# A303 Sparkford to Ilchester Dualling Scheme TR010036

## 9.2 Environmental Statement Table of Errata

**Environmental Statement Table of Errata**

<b>Regulation Number:</b>	
<b>Planning Inspectorate Scheme Reference</b>	TR010036
<b>Application Document Reference</b>	9.2
<b>Author:</b>	A303 Sparkford to Ilchester Dualling Scheme Project Team, Highways England

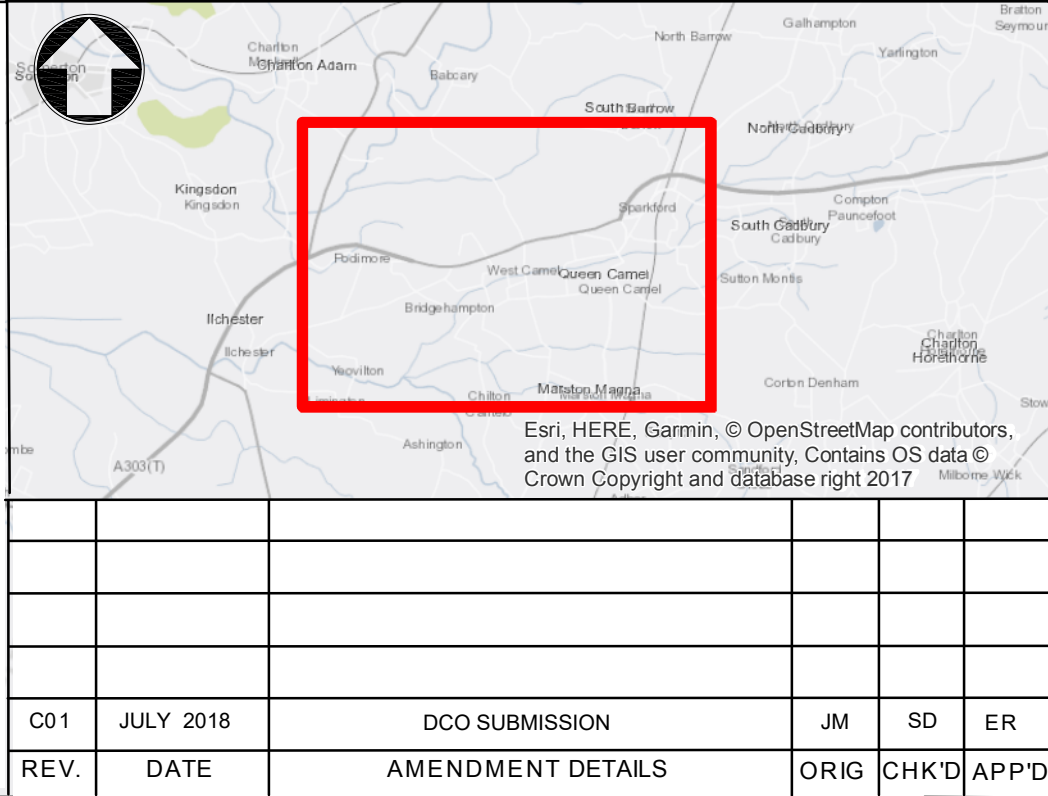
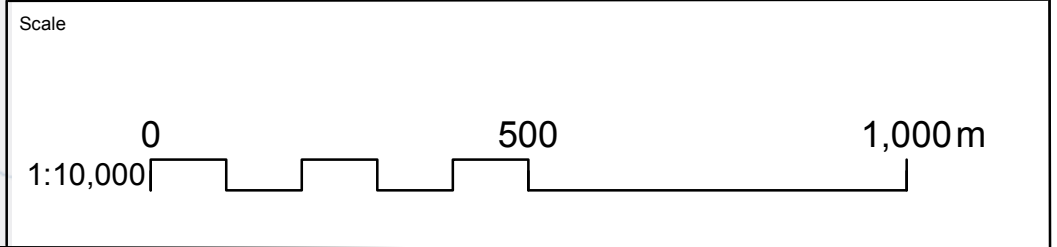
1.4.11	Volume 6.1 Environmental Statement Chapter 11 Noise and Vibration (APP-044)	22 - 23	The operational study area depicted in Figure 11.1 in Chapter 11 of the ES (APP-048) is inconsistent with the operational study area described in Chapter 11 section 11.6. Can this be rectified please?	Amended in response to ExA question 1.4.11. Referred to the wrong appendix figures in paragraphs 11.6.1 and 11.6.2.	<p>Paragraphs 11.6.1 and 11.6.2 of Environmental Statement Chapter 11 Noise and Vibration (APP-048) are amended to:</p> <p><i>"The assessment area for temporary noise and vibration impacts during construction is 300 metres from construction activity (seen in Figure 11.42 Construction Noise Study Area, Volume 6.2) due to the nature of the noise sources, the typical distances from source to receptor, and professional experience for the likely area of potential adverse effects from similar highways construction assessments."</i></p> <p><i>"HD213/11 provides the methodology for assessment of road projects within the UK. The methodology, which has been applied for the purposes of this assessment, requires that the study area is identified as an area within 1 kilometre of the physical works associated with the scheme. Within this study area, road traffic noise calculations are performed at any sensitive receptor within 600 metres of a road where there is a possibility of a change of 1dB LA10,18hr upon scheme opening, or 3dB LA10,18hr in the long</i></p>

ExA Question no.	Document number	Page no	ExA Written Question	Reason for amendment to the Environmental Statement	Amendment to the Environmental Statement
					<i>term. The operational noise calculation area is shown in Figure 11.21 Operational Noise Study Area, Volume 6.2."</i>
